13-15 & 17 Oxford Street and 2 Verona Street, Paddington

Submissions Report

Drawing Title
CROSS VENTILATION DIAGRAMS - 1

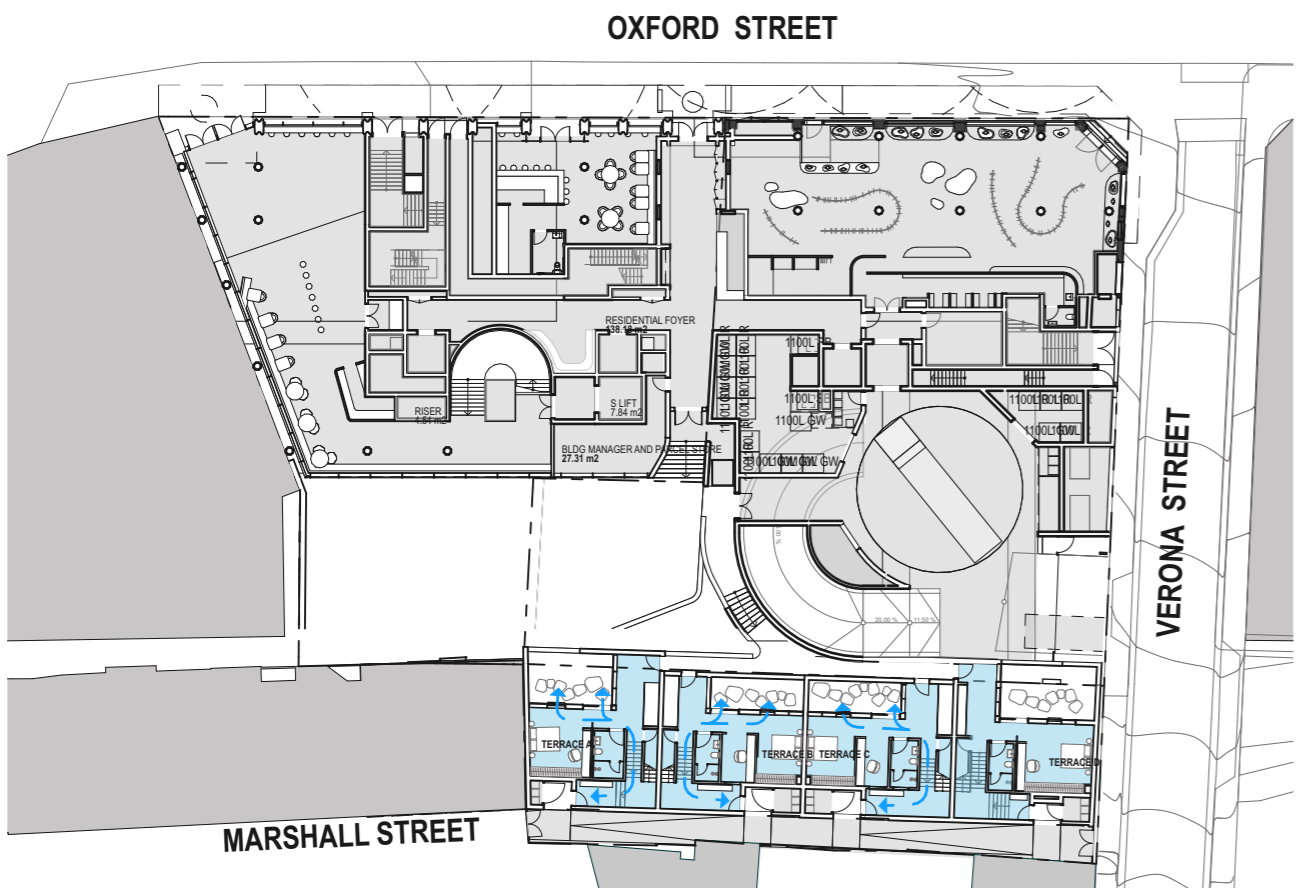
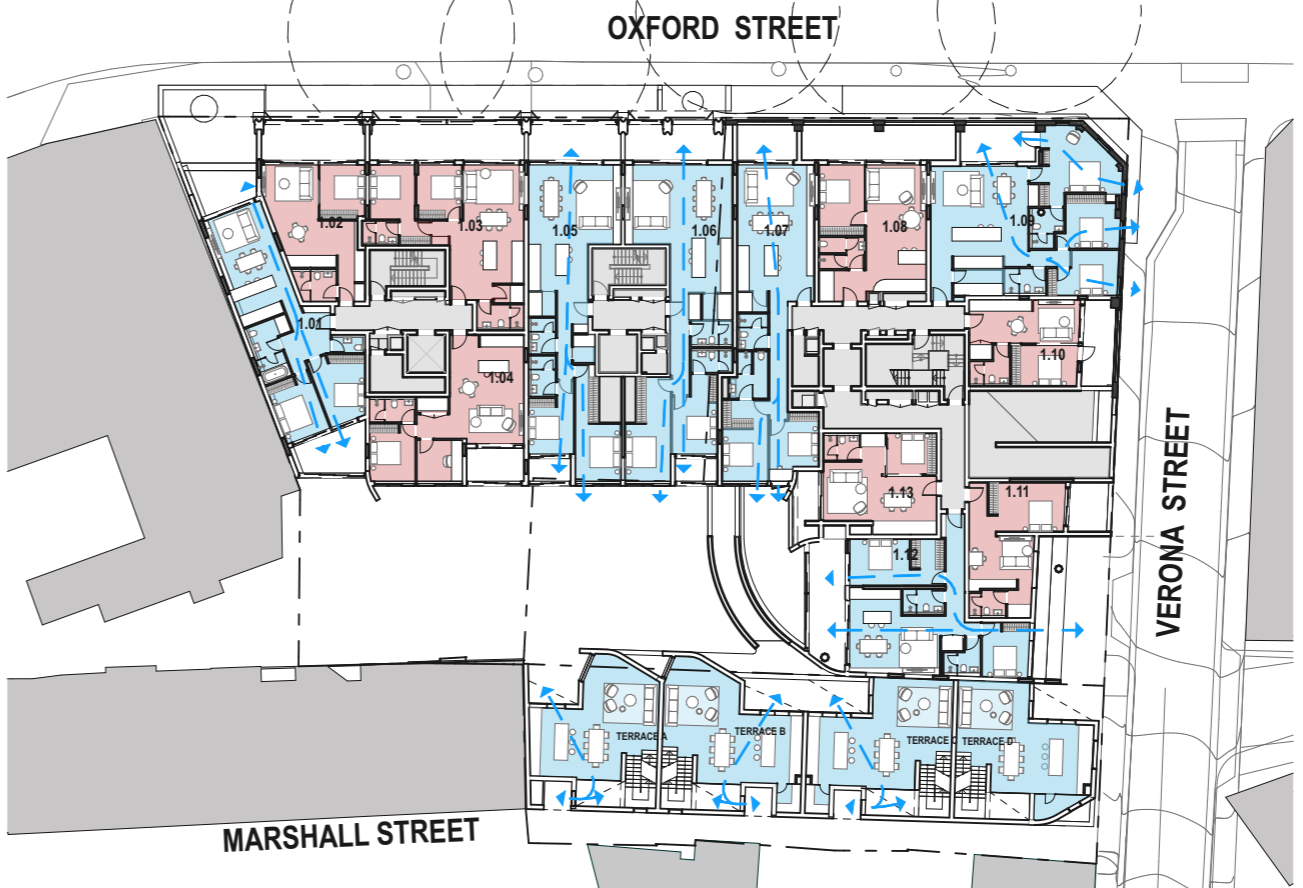
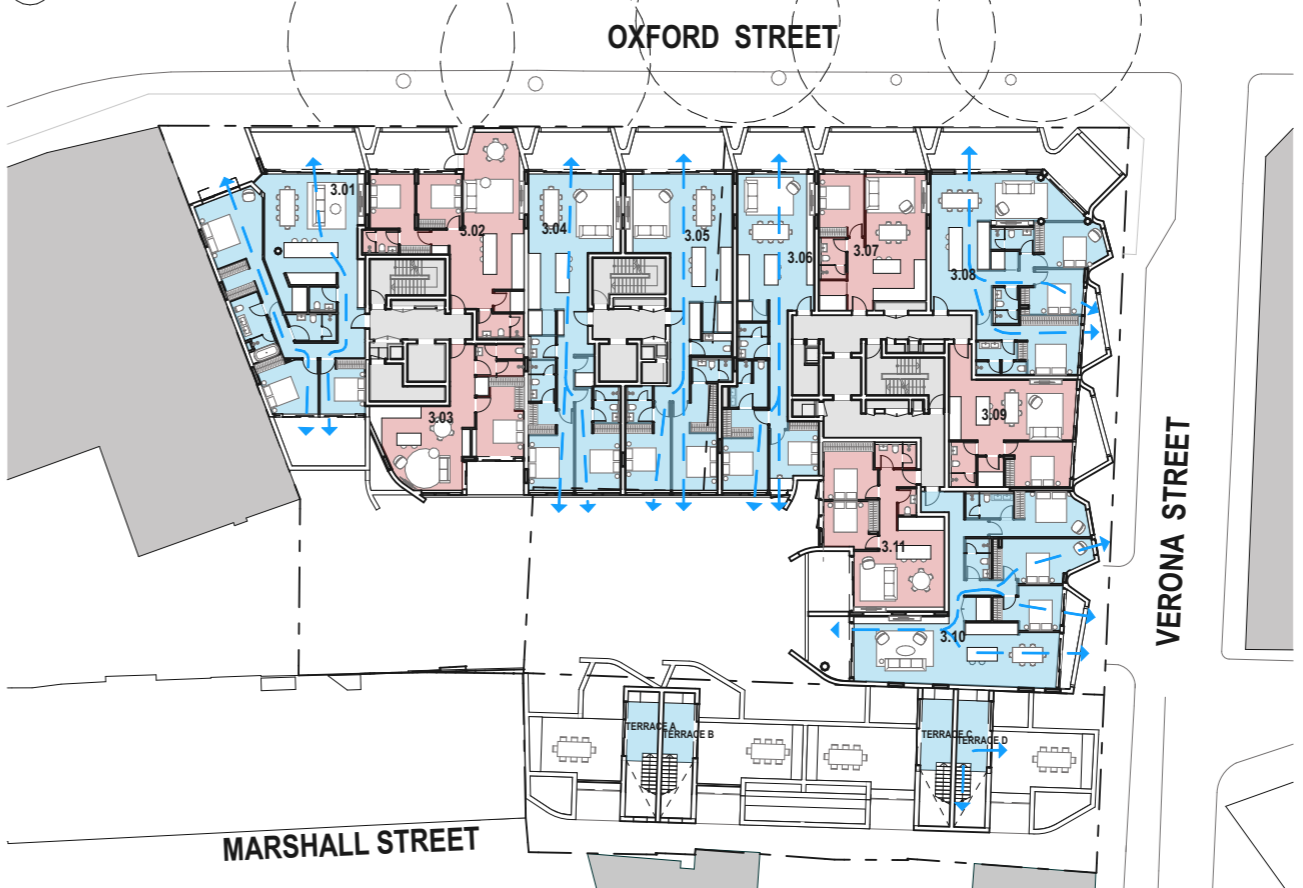
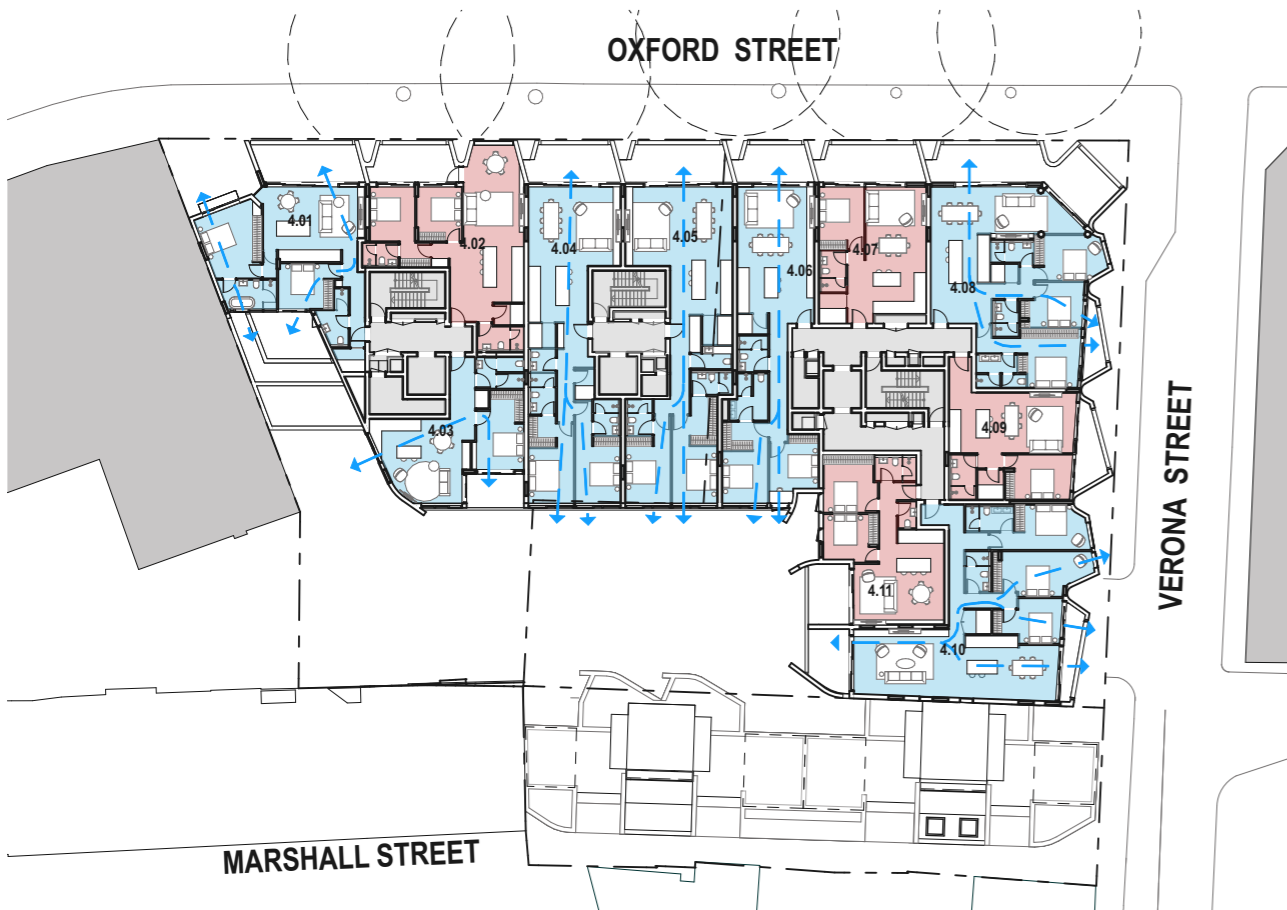
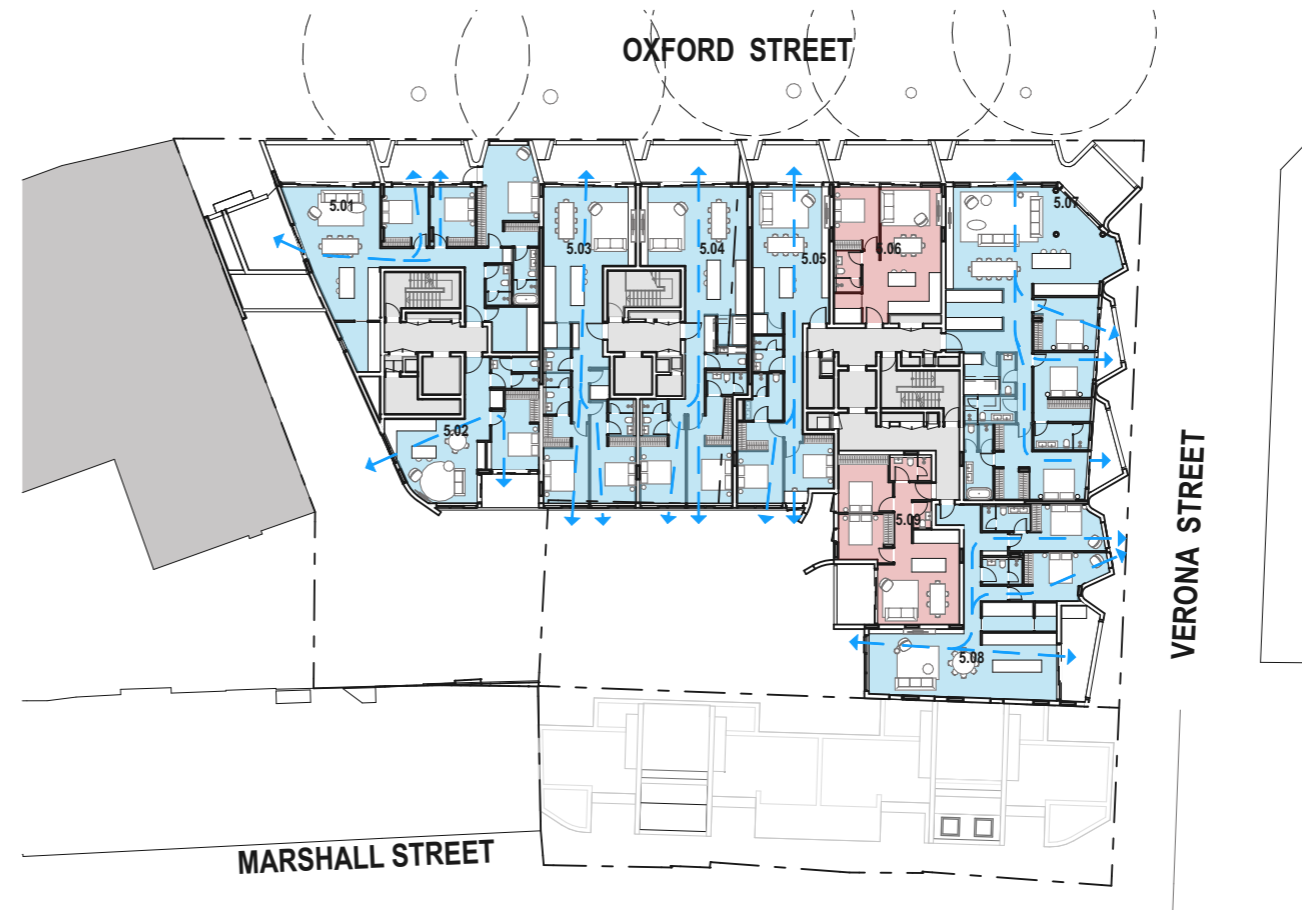
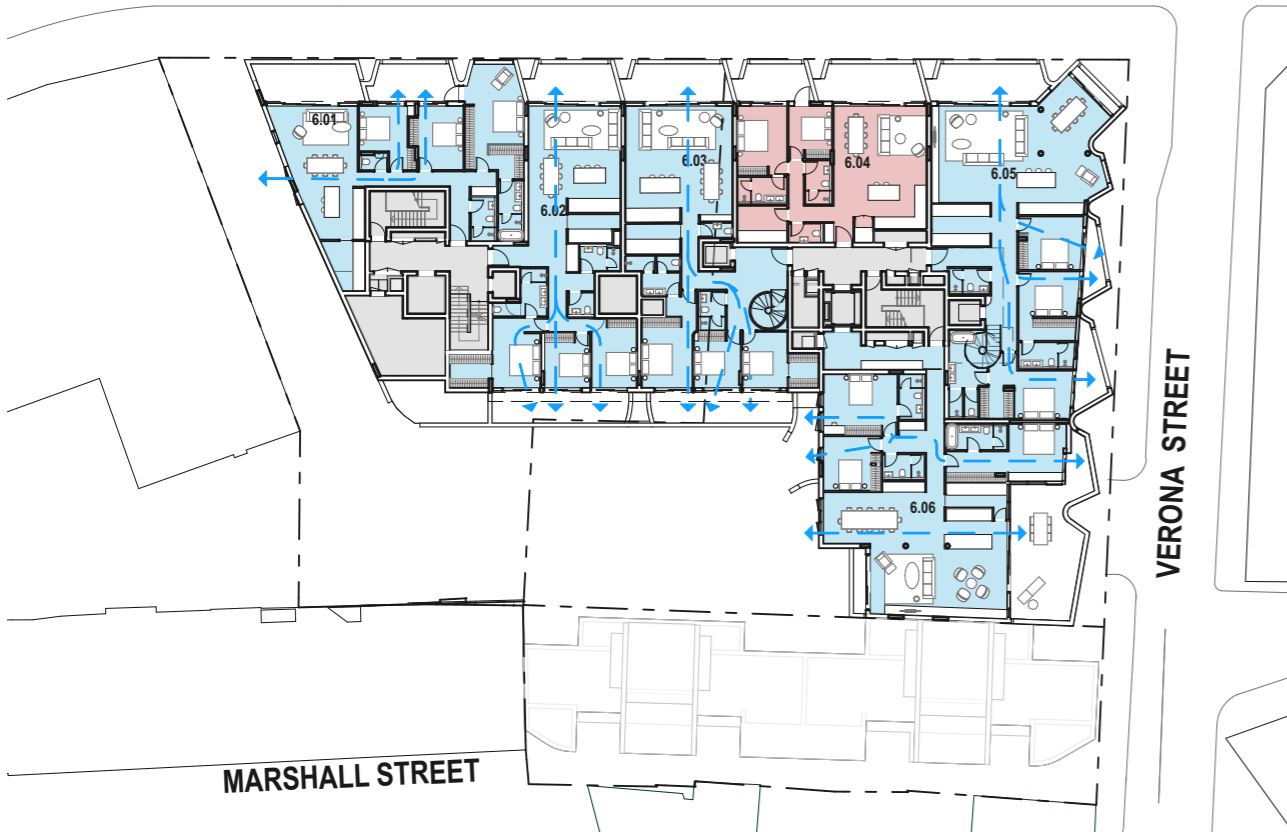
<p><i>Natural cross ventilation</i></p> <p>15. Clarify cross ventilation calculations, noting that Terraces A, B, C and D do not appear to be naturally cross-ventilated.</p>	<p>Cross ventilation is achieved for Terraces A, B, C via a dedicated airflow pathway that traverses the full depth of each dwelling. The cross-ventilation pathway is illustrated in the 3D section drawing included within the TZG Design Report.</p> <p>Terrace D does not achieve cross ventilation and the cross ventilation calculations reflect this. For Terraces A, B and C, fresh air enters each terrace from the north east courtyard elevation through floor to ceiling louvres measuring 2,420 x 3,100mm (inlet area 7.5sqm). Air then passes through a void space within the dwelling before exhausting via operable windows of 1,000 x 1,265mm (outlet area 1.27sqm) positioned above the entry door on the south west street elevation.</p> <p>The two openings are on different aspects of the building, satisfying the cross ventilation directional requirement of the Apartment Design Guide (ADG). The north east courtyard elevation receives the prevailing north east to easterly sea breeze during summer afternoons, the period of greatest thermal stress and therefore greatest benefit to occupant comfort. The aggregate opening area of 8.77sqm is tested against the ADG minimum of 5% of the floor area of the habitable space served.</p> <p>The terrace floor area is 49sqm, giving a minimum required opening area of 2.45sqm. The provided aggregate opening area of 8.77sqm represents 17.9% of floor area, exceeding the ADG requirement by a considerable margin. The cross ventilation strategy for Terraces A–C therefore satisfies the requirements of ADG Section 4D.</p>
